COUNTY FILE NO: PPR2140

DESIGN: NQ
REVIEW: RB
05/30/2025
H-SCALE: 1" = 40'
V-SCALE: N/A
SHEET
1 OF 1

SITE PLAN

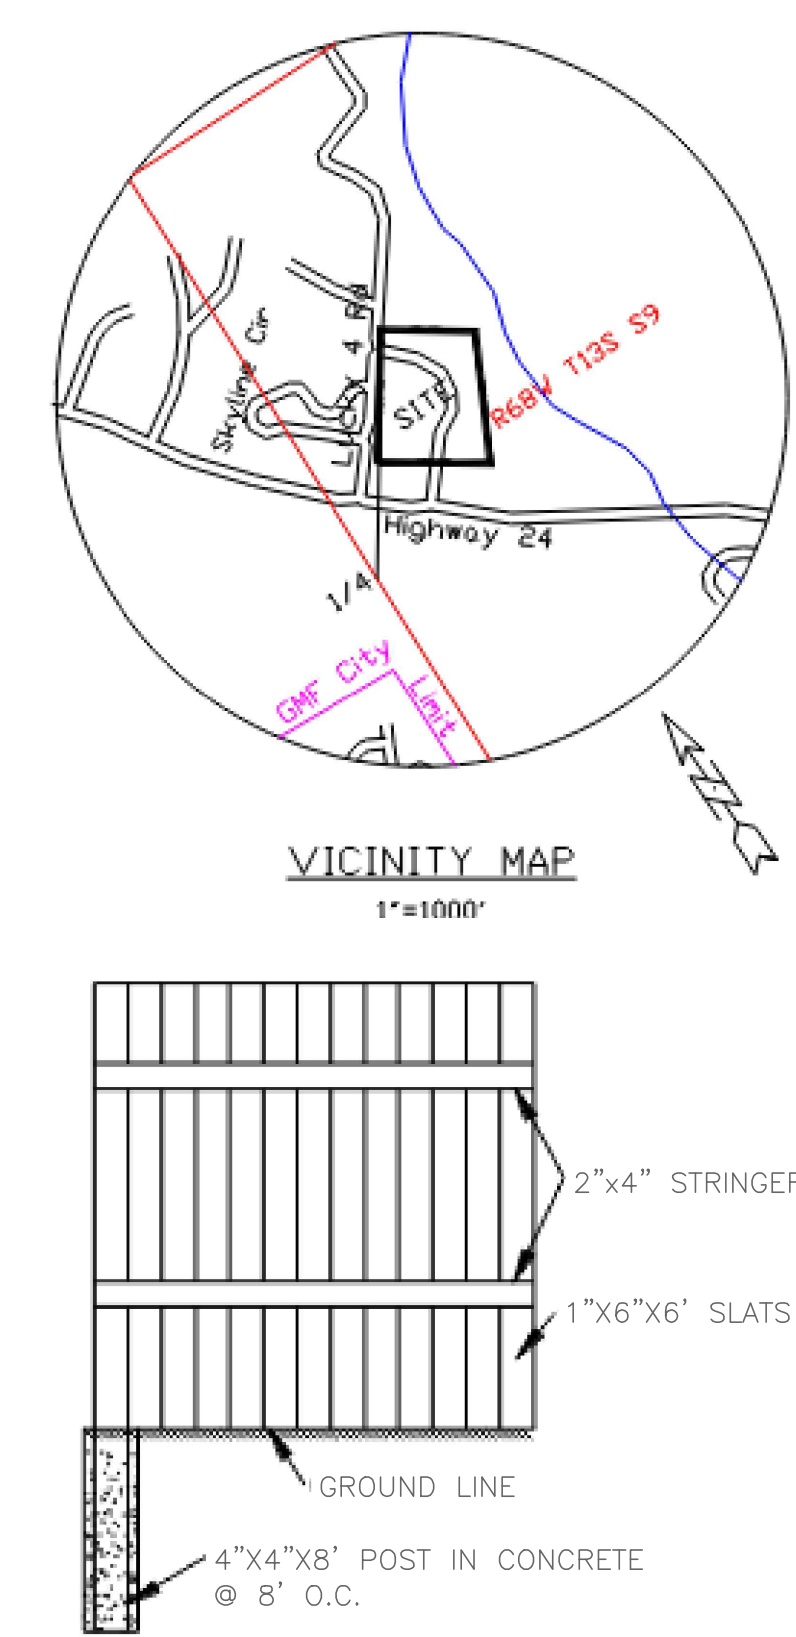
Add to legend:
X---X---X existing fence (type)
O---O---O existing fence (type)
trash dumpster
pavement driveway
gravel driveway

Please add the following note:
The owner agrees on behalf of him/herself and any developer or builder successors and assignees that traffic impact fees shall be paid in accordance with the El Paso County Road Impact Fee Program Resolution (Resolution No. 24-377), or any amendments thereto, at or prior to the time of site development plan approval.

Add a note for fencing similar to the one added for retaining walls. (All fencing will be less than 7' tall.)
SITE NOTES 1-6 FROM PREVIOUS SUBMITTAL NEED TO BE ADDED AGAIN:

ADD VA185 CONDITIONS OF APPROVAL #2 AND #3 INTO THE SITE NOTES FOR FUTURE REFERENCE.

ALL INFORMATION BELOW NEEDS TO BE ADDED AGAIN:
